**CRAWFORD APARTMENTS**

**EXTERIOR LIGHTING PLAN**

COUNTY FILE NUMBER: PPR2257

PLAN - EXTERIOR LIGHTING
SCALE: 1"=20'

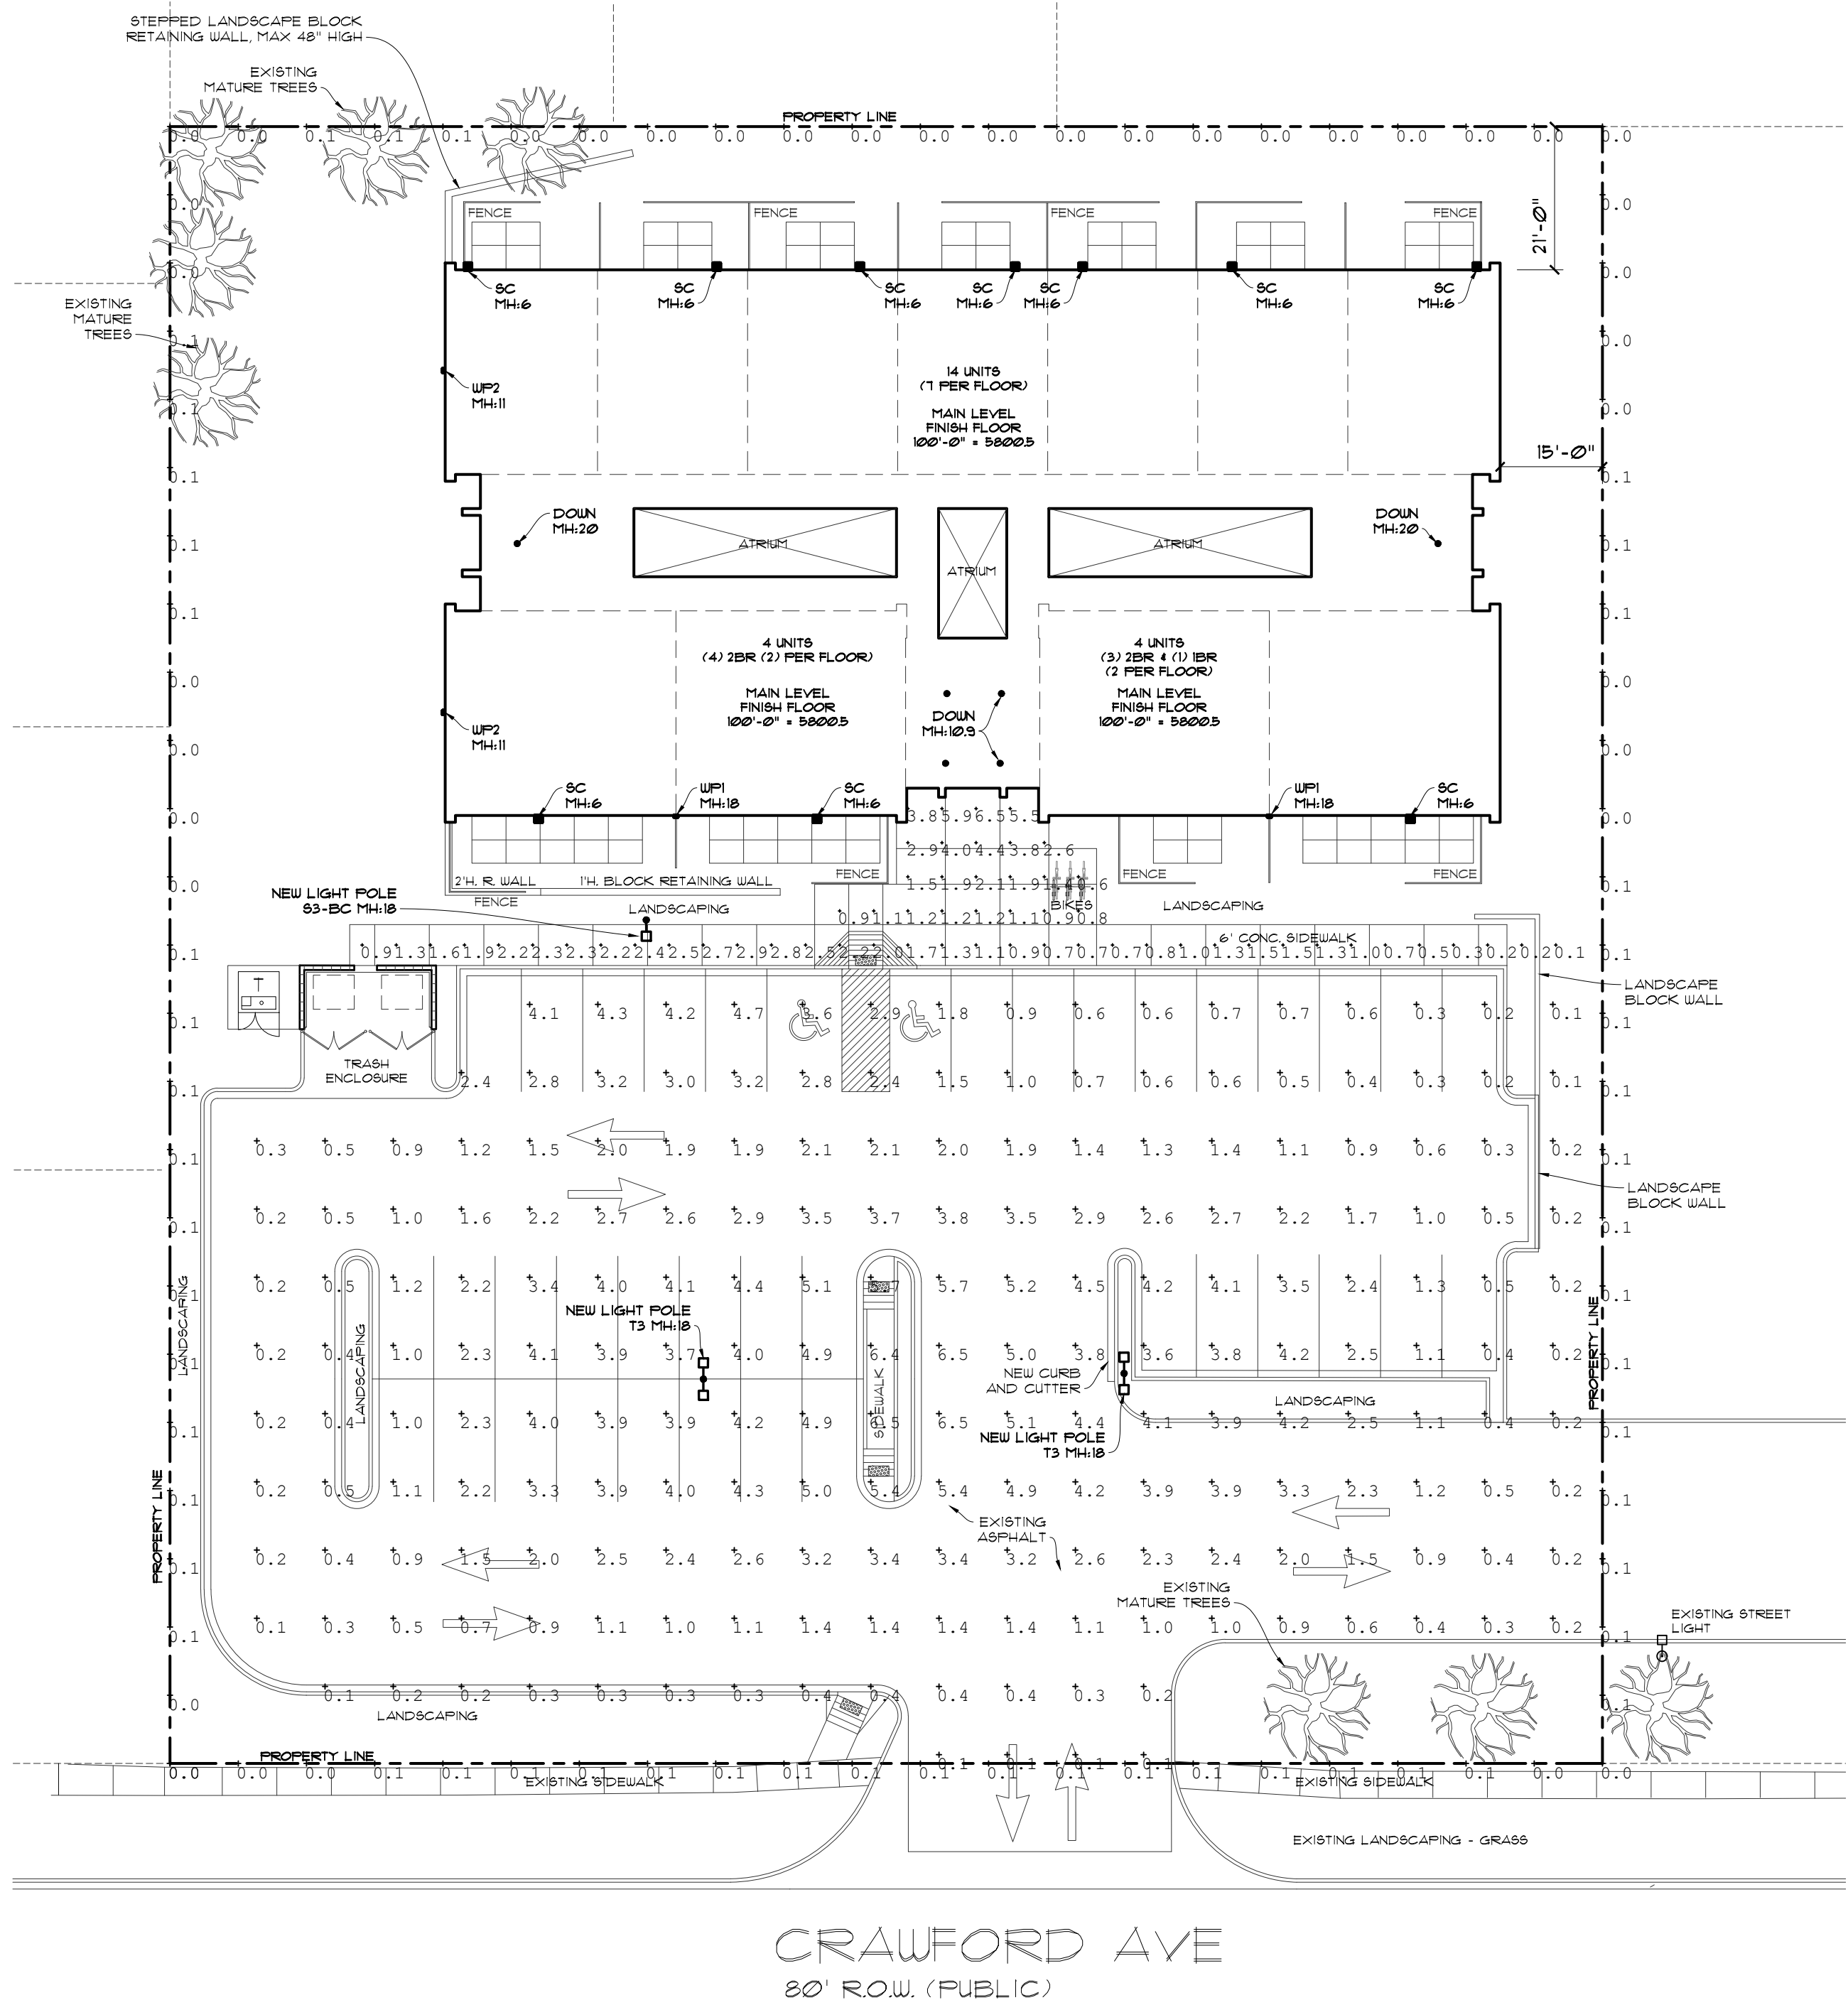
**UNRESOLVED V1 COMMENT:**  
 Lighting levels near a ROW or residential neighboring property must not exceed 0.1 foot candle levels, please adjust.  
 Section 6.2.3.B.1.e
